Application by Highways England for a Development Consent Order in relation to the A585 Windy Harbour to Skippool Improvement Scheme (TR010035)

Fylde Borough Council (our reference: 20021788)

Deadline 2: Responses to the Examining Authority’s first written questions ExQ1 (FBC document reference 2.4)

Project A585 WINDY HARBOUR TO SKIPPOOL IMPROVEMENT SCHEME  
Drawing Title ENVIRONMENTAL MASTERPLAN SHEET 5 OF 32

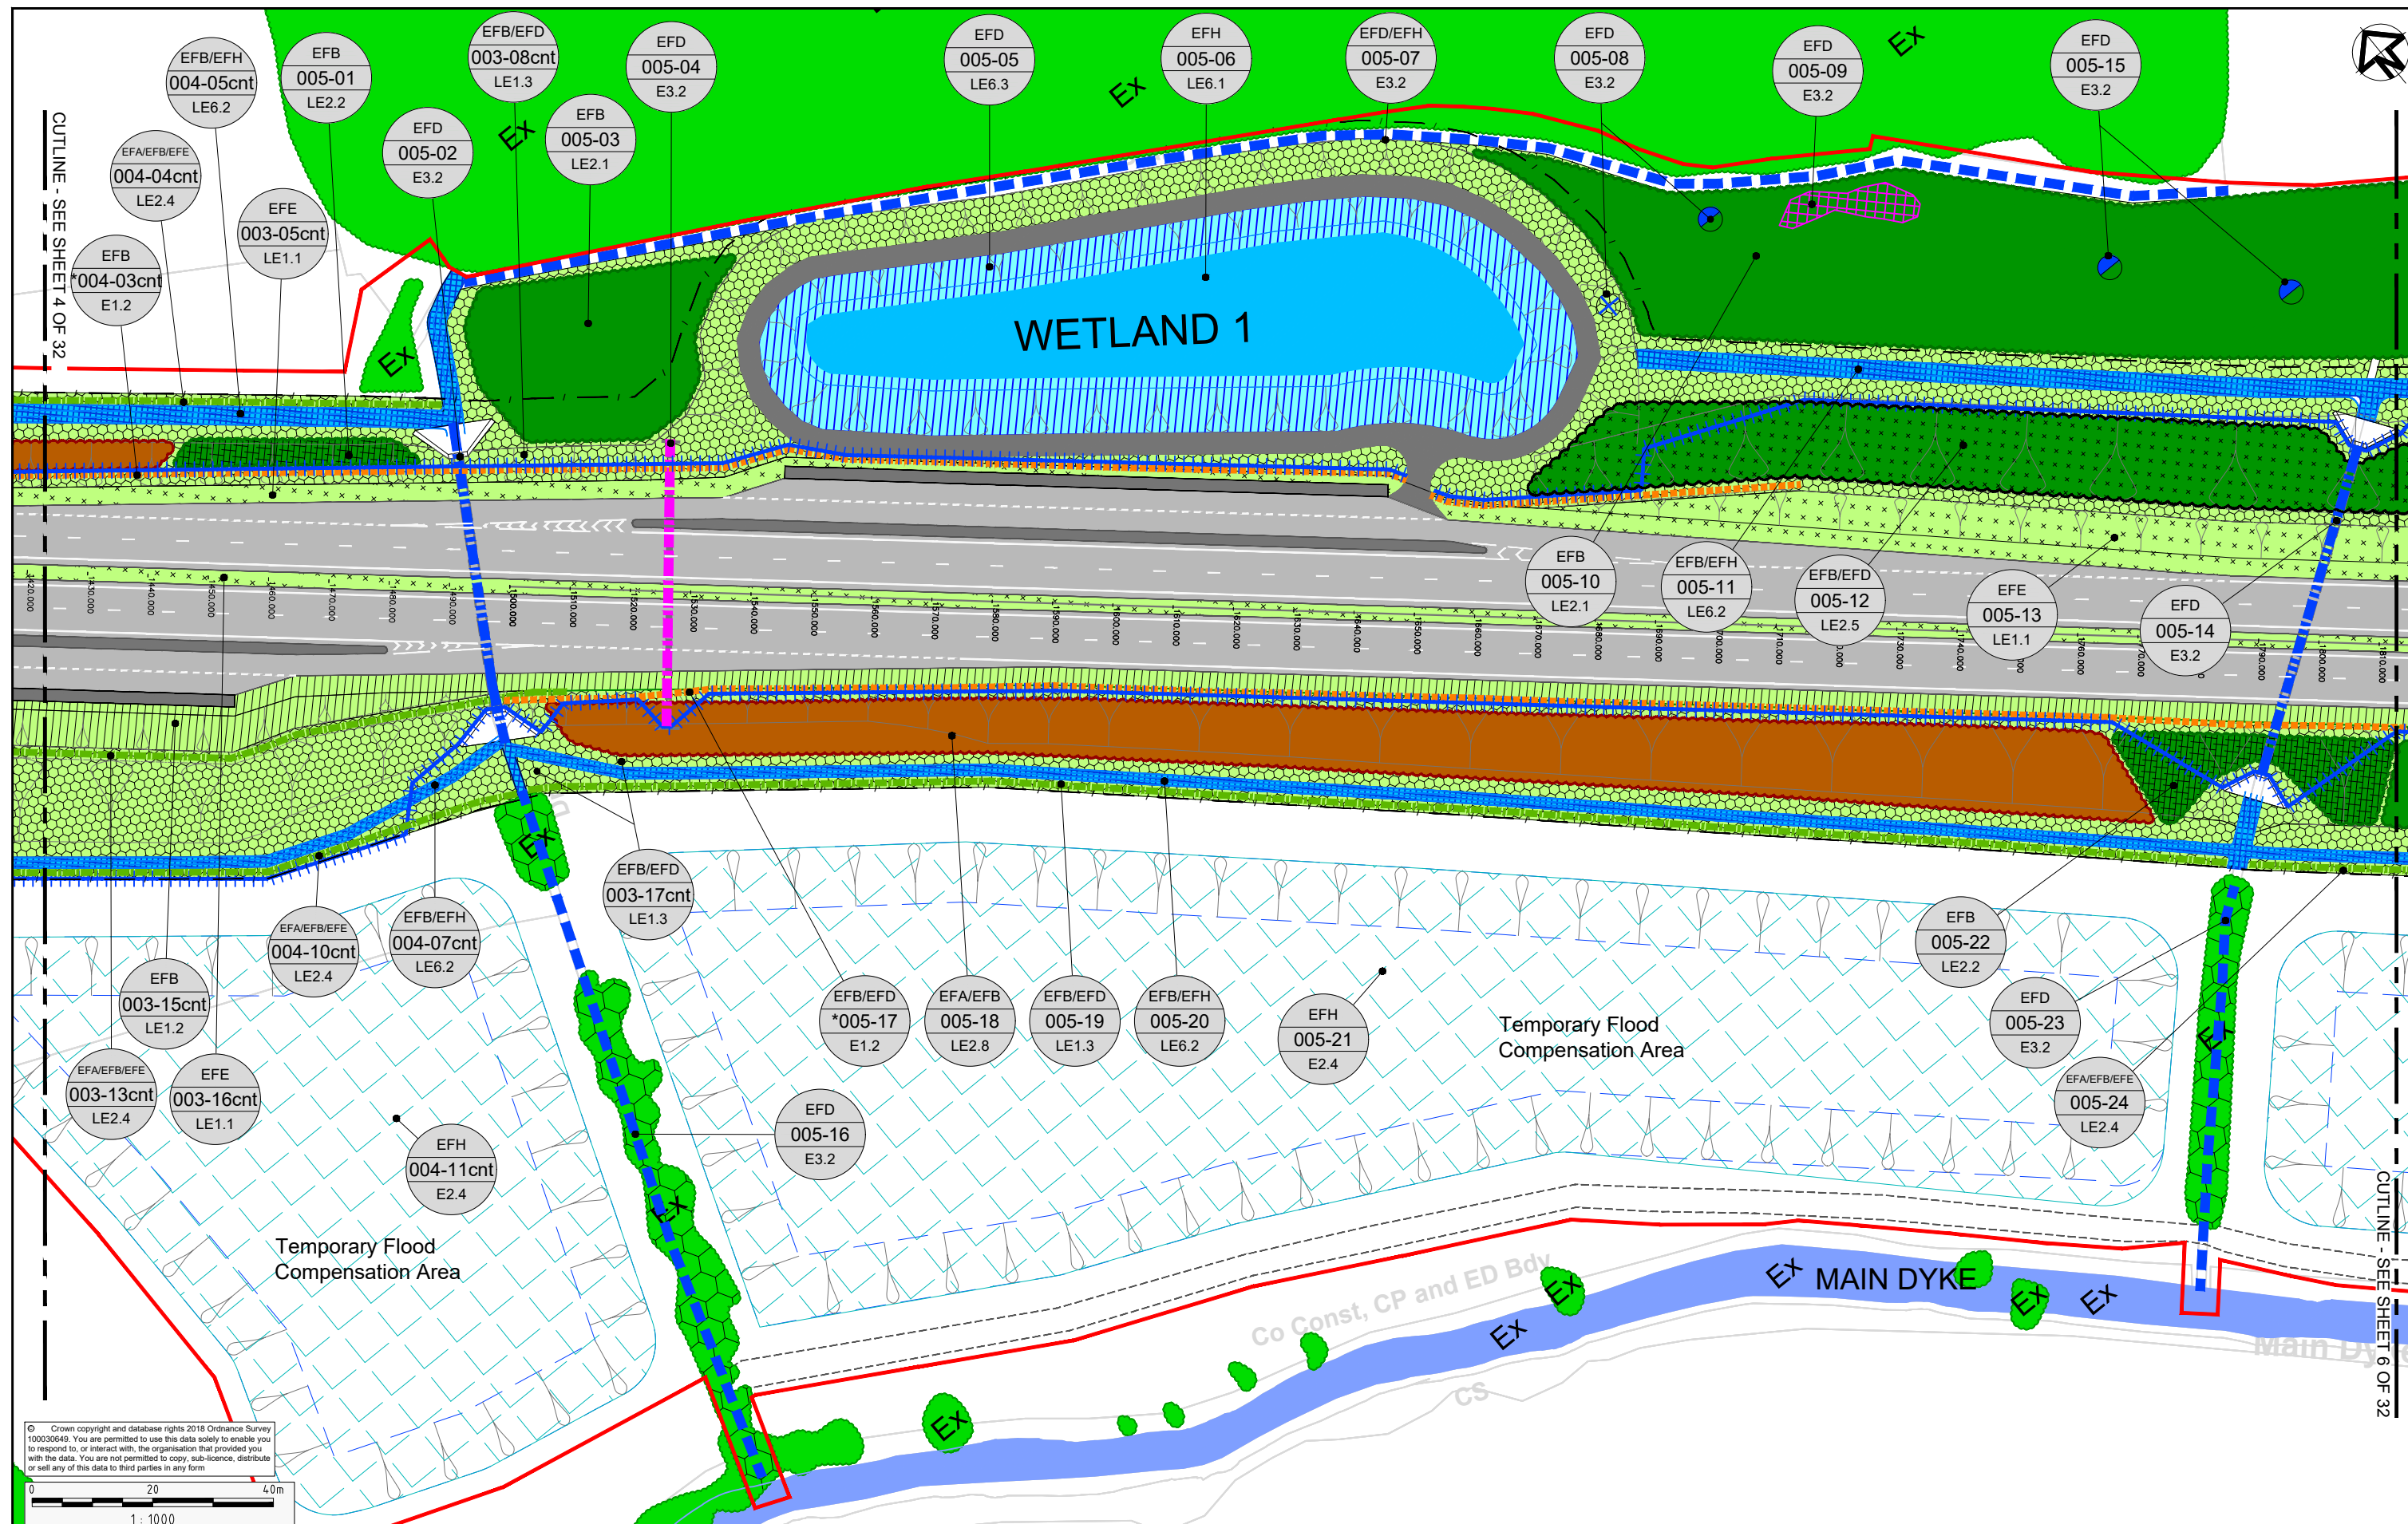
1.4.3.	<p>Heritage Assets</p> <p>A 2m high noise barrier is proposed to the east of the Lodge Lane bridge, along the southern edge of the bypass where it flanks Barnfield Manor and The Manor. This noise barrier is shown as an acoustic fence backed by low-level planting on viewpoint 10 of document 6.9 to the ES. The LPA considers that it would be preferable for this fence to be replaced with an alternative boundary treatment (e.g. a red brick wall) to afford a more sympathetic relationship with the vernacular of neighbouring buildings. Can the Applicant give its views on this and if the road at this point is in a cutting, is a barrier needed for noise attenuation purposes?</p>	<p>The question includes an accurate summary of FBC's comments concerning the visual impact of the noise barrier in question on the significance of surrounding heritage assets as set out in its Relevant Representation.</p> <p>It appears, however, that this question is directed to the Applicant to provide a response and so FBC does not have any further comments to add beyond those contained in its Relevant Representation. It does, however, appear to FBC that the noise barrier is required in order to attenuate sound to the post-development levels identified in Chapter 11 (document reference 6.11) of the ES. Therefore, FBC maintains its position that a bespoke treatment for this barrier should be provided, rather than a 2m high close-boarded fence.</p>
